Wansford Parish Council

Deadline 6 Submission

Comments on Document 9.25 Applicant's Response to the Examining Authority's Further Written Questions Annex E: A47/A1 Western Roundabout Traffic Signal Option Assessment Technical Note

A47 Wansford to Sutton Dualling

Figure 2.1: Layout of the A47/A1 Western roundabout

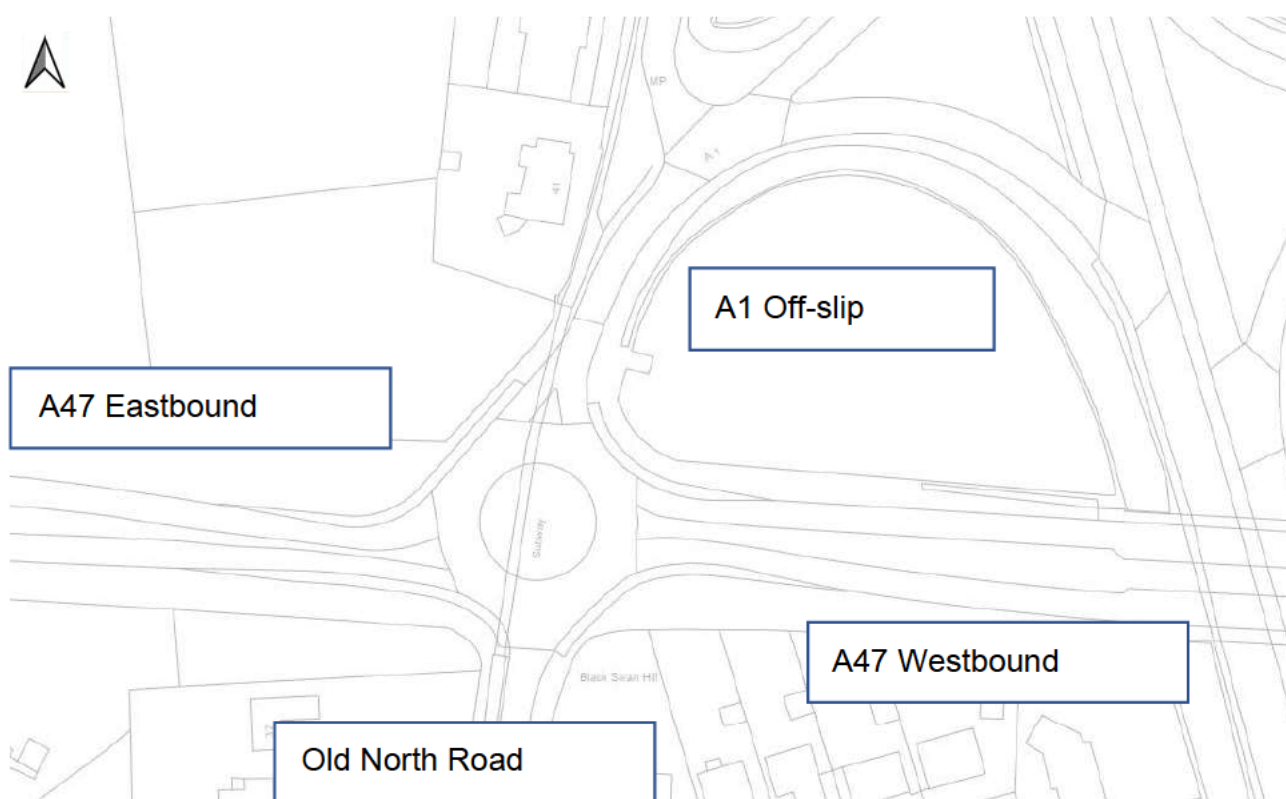
Annex E contains the same technical note that Wansford Parish Council reviewed and commented on several months ago. As stated at the time, the analysis used is very basic and it is likely that considerable improvements in the performance of the junction could be achieved if the scheme was optimised. Areas of optimisation include:

1. The lengthening of all dedicated right turn lanes to improve the number of vehicles accommodated and to prevent interference with vehicles wanting to turn left or carry straight on. The main example of this is for vehicles heading west on the A47 and wanting to turn right onto the A1 northbound. National Highways has shown this as 90m while in reality it is 225m.
2. Using an "intelligent" traffic light system which adapts the timing of the signals to the individual traffic flows. The need for this is clear because of the considerable differences in the balance of the various flows through the day. The modelling was based on a crude fixed period control system.

National Highways (NH) have discarded the use of a signalled junction because they say that it does not solve the problems of the western roundabout. It does however show a small improvement on the proposed do something case and with further optimisation this gain can be increased.
